**RE: POWERHOUSE ULTIMO REVITALISATION – SSD 67588459
MODIFICATION 1 – RESPONSE TO SUBMISSIONS (HERITAGE)**

This addendum to the Heritage Impact Statement (HIS) has been prepared to provide a response to heritage matters raised during the public exhibition of Modification 1 of SSD-67588459 for the Powerhouse Revitalisation Ultimo (PUR) project. In response to the submissions a number of minor changes have been proposed to the scheme, these changes have been described below and have been assessed for potential heritage impact.

ELEVATION - EAST
SCALE: 1:200

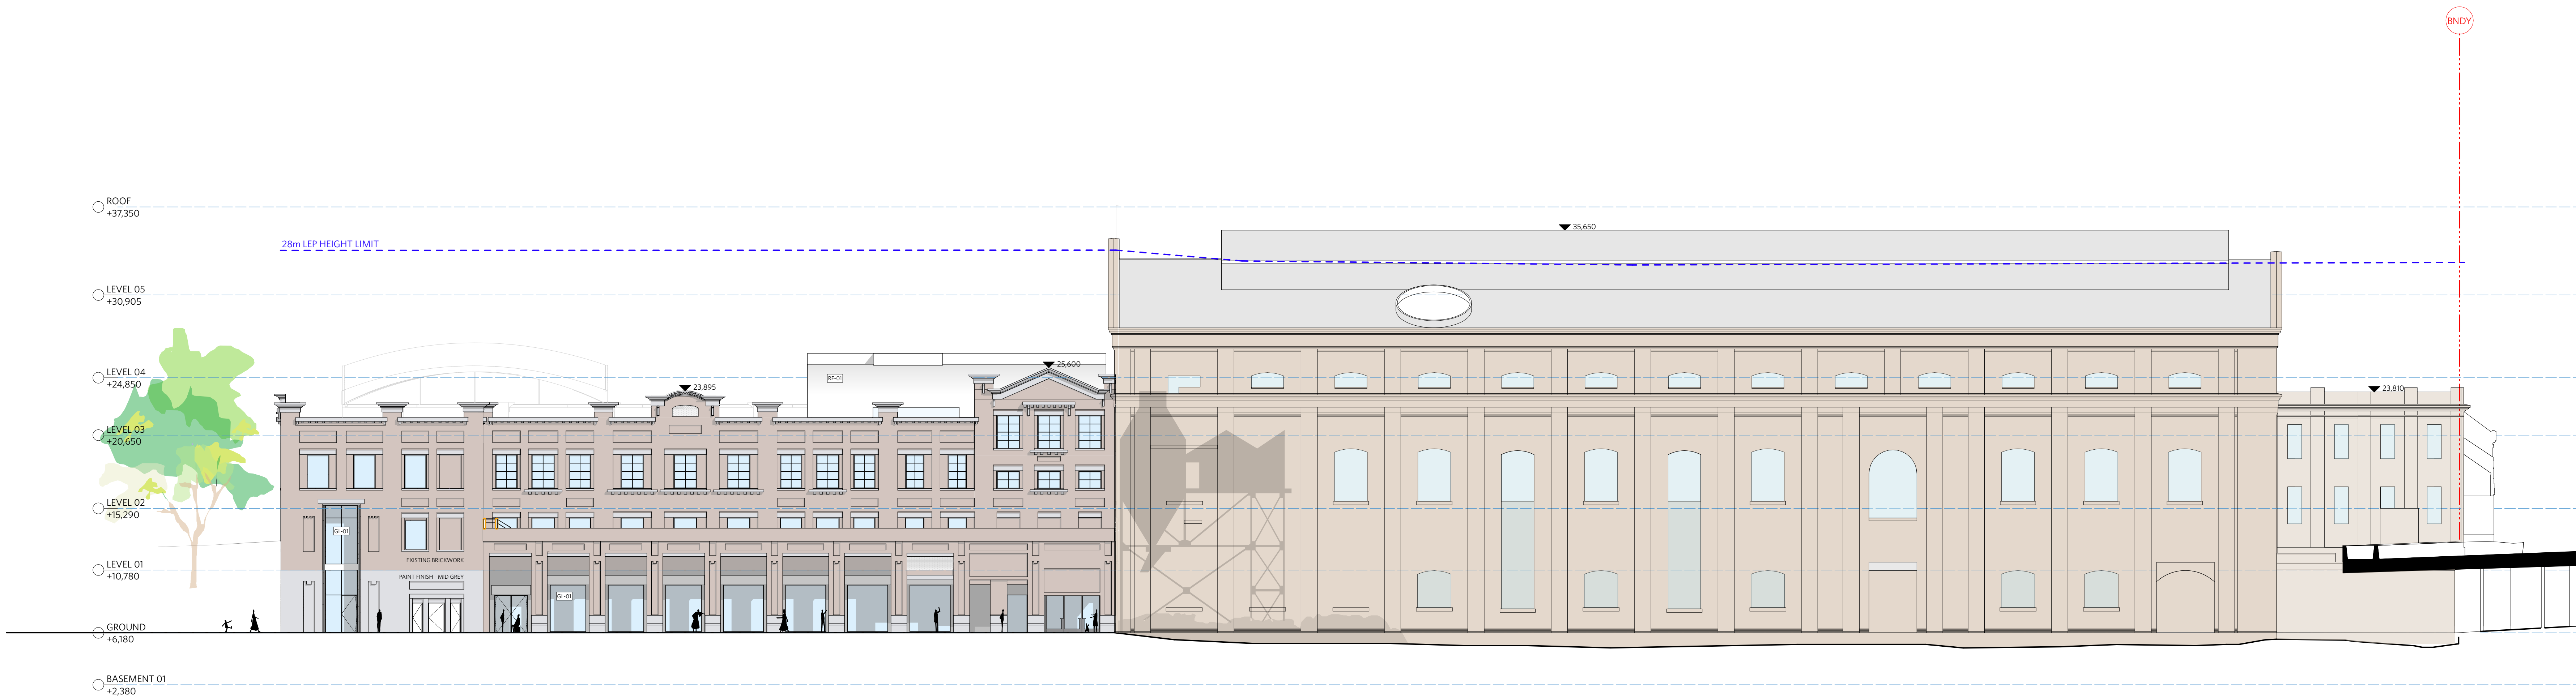
HC4 Recommends that the high-level glazing to the eastern side of the Galleria, including the lower raked section that connects to the adjacent building, be replaced with new continuous glazing in keeping with the original design. It is considered that the proposed use of opaque cladding, particularly to replace the lower raked glazing, would have an adverse heritage impact.

HC4 *Recommends that the high-level glazing to the eastern side of the Galleria, including the lower raked section that connects to the adjacent building, be replaced with new continuous glazing in keeping with the original design.*

CoS8 The removal of the existing upper most level and reinstatement of a low pitched roof also provides the opportunity to remove the high lift overrun and lift core which is now no longer required for the existing upper most level or the previously proposed rooftop bar. Further amendments should be required to resolve this element as the proposed arrangement leaves a visually intrusive and redundant lift overrun

HC7 Recommends that the lift and stair should not project above the Switch House roof and become visually obtrusive. It is noted that the lift and stair access will no longer be required to the roof level.

The Modification proposes the replacement of the existing linear window with a series of high-level windows that sit above a new junction flashing detail, set well above the upper edge of the box gutter. The composition of the proposed high-level windows is an integral part of the character of the contemporary interior design of the Galleria space. These windows are not visible from the public domain, and their contribution is limited to the internal character of the space.

Whilst the original design provided a clear distinction between the existing and new buildings at high level, the approved design provides an alternative approach to making a demarcation between the Galleria and the Engine House and Turbine Hall. The visual relationship between the two buildings remains, with discrete views of the eastern elevation of the Engine House and Turbine Hall forming an integral part of the backdrop to the Galleria space, however rather than the two buildings reading as 'separated' the Engine House and Turbine Hall walls read 'through' the new lining of the space. The insertion of a high-level line of glazing introduces an incompatible element to the approved design concept and potentially compromises the contemporary concept for the museum space.

As noted, the original design of the glazed junction between the new and historic buildings created a box gutter which has led to ongoing maintenance issues. It is not considered an appropriate response, nor good heritage practice, to reconstruct an original design if it leads to ongoing damage.

**Figure 3 |** Wran Building / Galleria additional steel structure demolition works and glazing (Base source: Applicant’s modification)

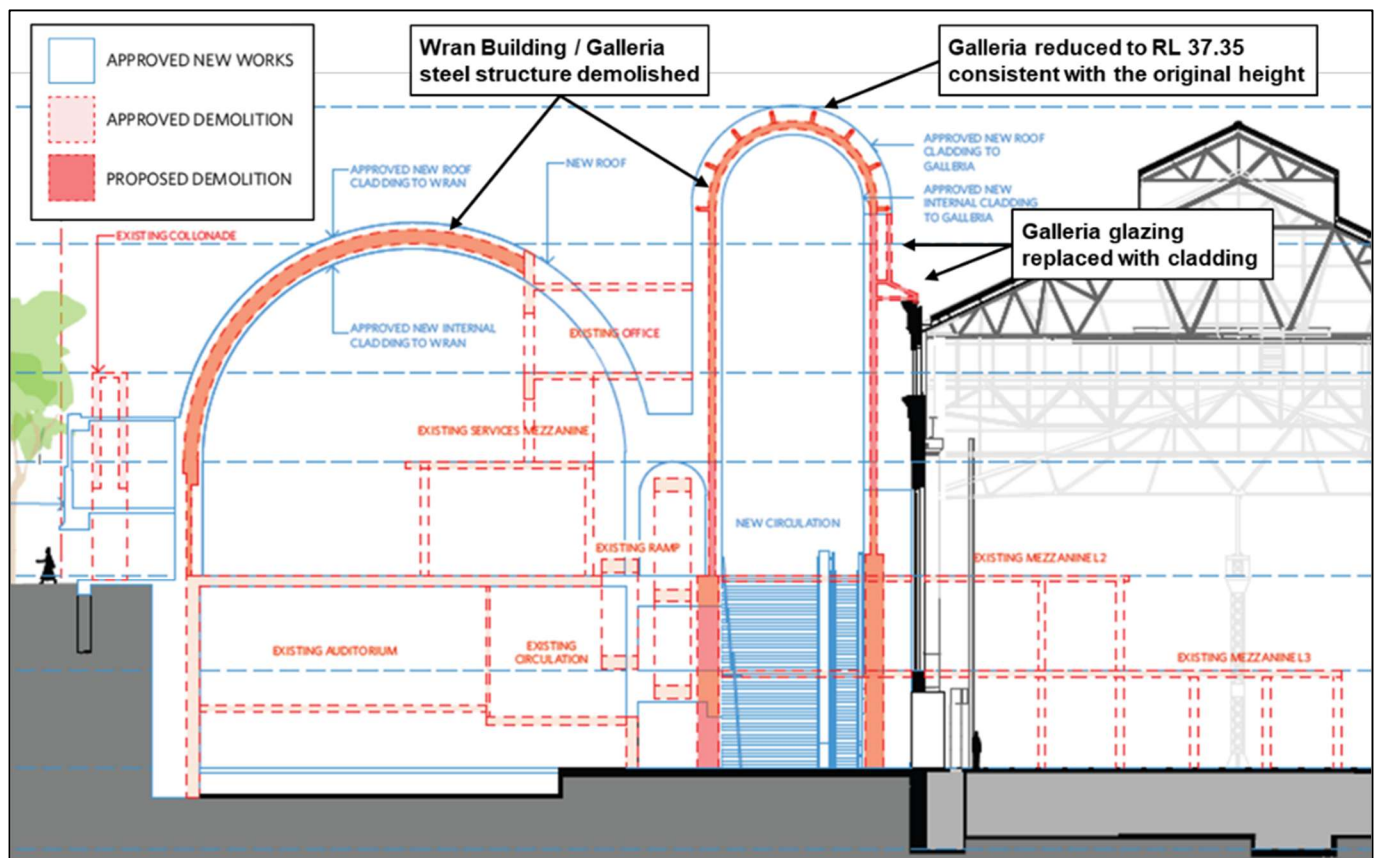
CoS3 The now total demolition and reconstruction of the Wran Building and Galleria structure is disappointing and not supported. The modification comes after commitments were made to Council and the community about the Wran Building. The removal and replacement of the structure and fabric of the Wran Building and Galleria represents demolition of a substantial amount of building fabric associated with the 1980s redevelopment of the site and is considered to have a negative impact on the significance of the Powerhouse Museum complex and the ability to interpret the different phases of use over time. The structure should be retained and adaptively reused at a minimum.

- CoS4 *More details should be provided to demonstrate the full extent of demolition and excavation works that will be required and how the new structures will be supported without damaging the existing footings of the adjacent building. Should the demolition of the Wran Building and Galleria be approved, then the Heritage Interpretation Strategy should be amended to account for the total loss of these structures.*
- HC3 *Recommends that the applicant considers the retention of the Galleria's existing steel structure in concert with the addition of a new independent steel structure.*

For these reasons, the modification proposes demolition of the existing structure and its replacement with new structure reconstructing the original arched forms. Further, the proposal is to reconstruct the distinctive arched portals in the Galleria space. This approach, reconstruction 'like for like', has the material advantage over simply constructing new framing in a segmented 'I' beams or a combination of other structural members of conserving an original design element, one which originally contributed to the visual character of the interior of the galleria space. These new portal frames would match the existing in size, portal profile (circular) and rhythm. Whilst the approved design does encapsulate the structure, these reconstructed elements would allow the original visual character of the Galleria to be recaptured in the future if desired.

In retaining the structure in its current location, the issues associated with constructability of the approved scheme and work site safety issues are not resolved.

The addition of a new independent steel structure was considered during the investigations, and in terms of preparing a structural design is technically possible, particularly in the context of the structure being approved to be encapsulated. However, in retaining the structure in its current location and in this case providing additional structure, the issues associated with constructability of the approved scheme and work site safety issues are not resolved.

**Figure 4** | Wran Building / Galleria steel structure and roof glazing (top) and proposed solid cladding and horizontal windows (bottom) (Base source: Applicant's RtS and additional information)

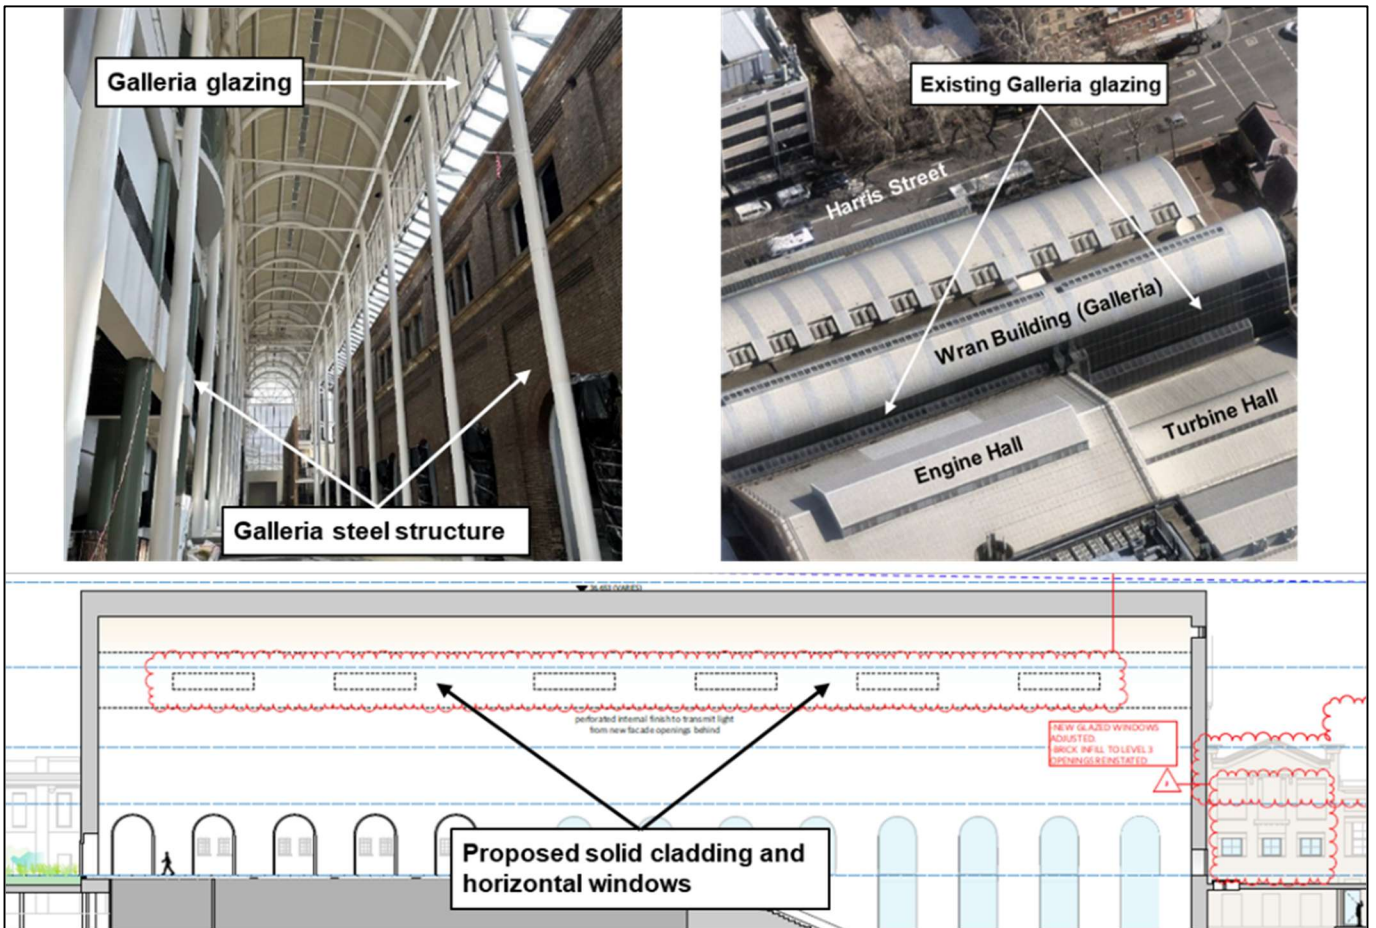
CoS5 Additionally, the Archaeological Assessment identifies the Powerhouse Ultimo site to have moderate to high potential to contain archaeological evidence related to this historical phase of use. This should address the increased excavation associated with the removal of the existing structures. The retention or reconstruction of the Galleria and glazing should also be considered. The existing glazing provides a lighter and more spatial experience within the Galleria.

CoS6 The proposed replacement glazing is smaller in area and would result in a 'heavier and darker' experience. The glazing line would also provide maintain a clear visual break between the structures, delineating the existing heritage buildings and new building.

The spatial volume of the Galleria will be conserved in the approved design, with a contemporary fitout and character. The proposed glazed openings have been designed to respond to a desired internal experience, in line with the approved proposal.
